CITY OF ALBUQUERQUE

March 3, 2017

Faizel Kassam, Vandy Investments, Inc.: fkassam@legacy-hospitality.com
Legacy NAA Apartments: Alameda and San Pedro
Copy: Matt Ferreira, Legacy Hospitality, Inc.: mferreira@legacy-hospitality.com

Re: Drainage Ordinance (14-5-2-1) Violations for Erosion and Sediment Control

Legacy NAA Apartments

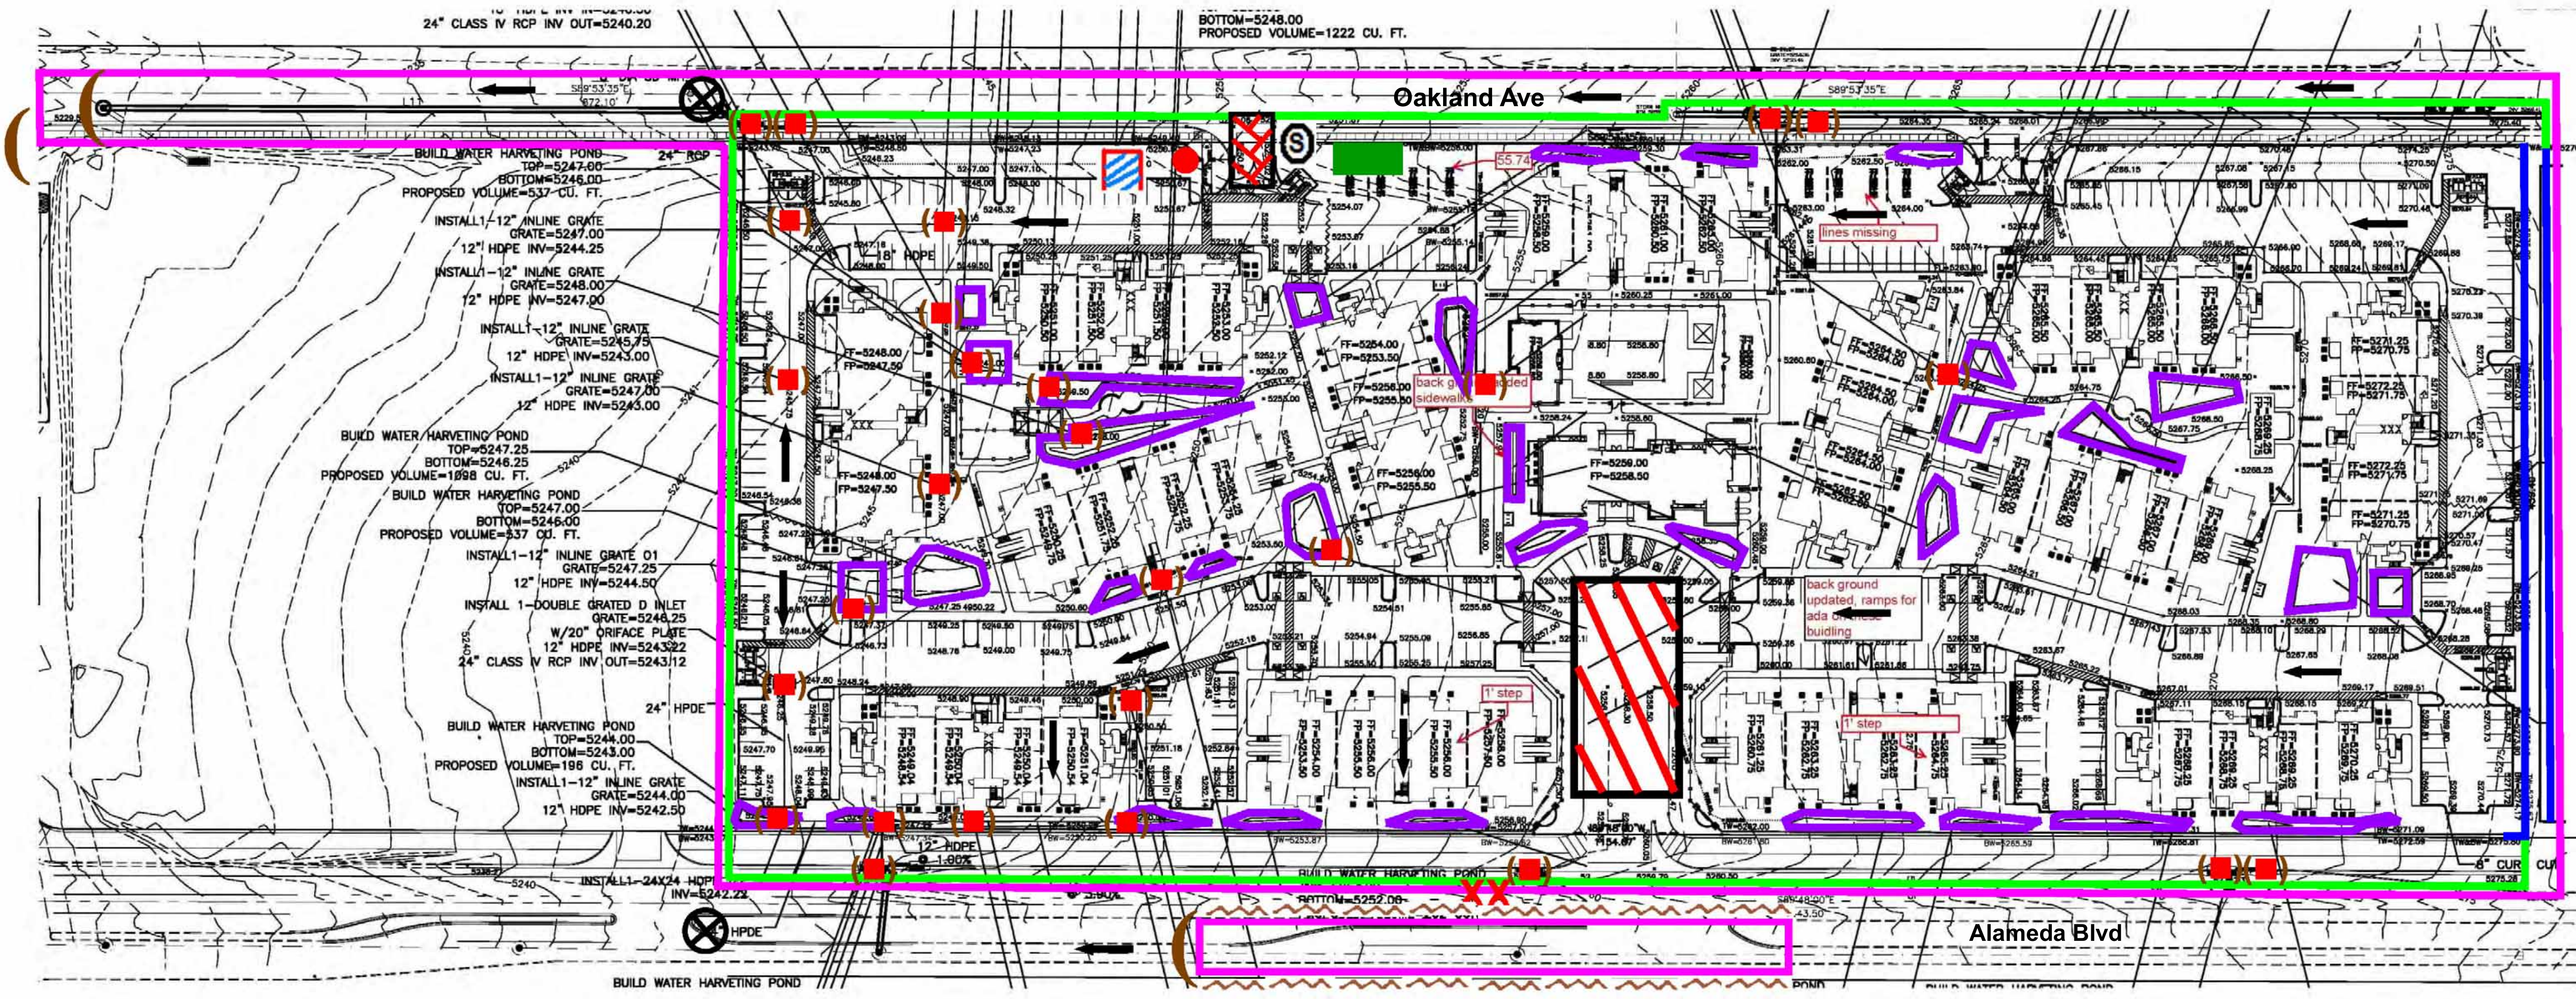
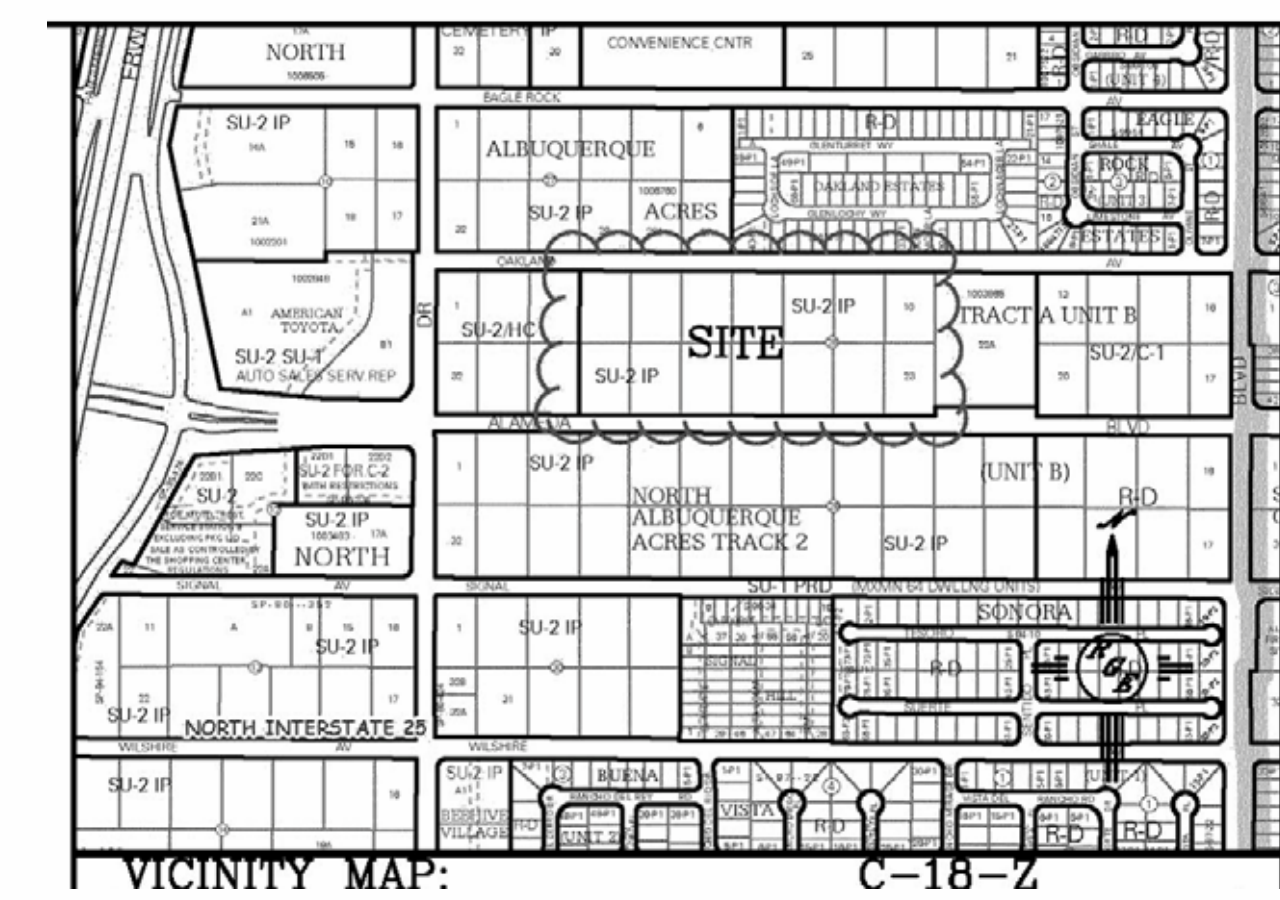
1. The Track-out pad/stabilized construction entrance was in poor condition and was required to be replaced.
2. Remove sediment from the gutter along the north side of Oakland Ave.

At today's inspection, the track-out pad/stabilized construction entrance was in poor condition and the sediment was still present in Oakland Ave.

1. A disturbed area along Alameda Blvd requires a sediment BMP.
2. The silt fence requires maintenance at the Northwest corner of the site.

1. Install a stabilized construction entrance per the approved Erosion and Sediment Control Plan.
2. Remove sediment from the gutter along the north side of Oakland Ave from this site's entrance to the east side of the drive pad shown in the photo below.

3. Install a sediment BMP south of the disturbed area along Alameda Blvd.
4. Perform maintenance on the silt fence at the northwest corner at the outfall.
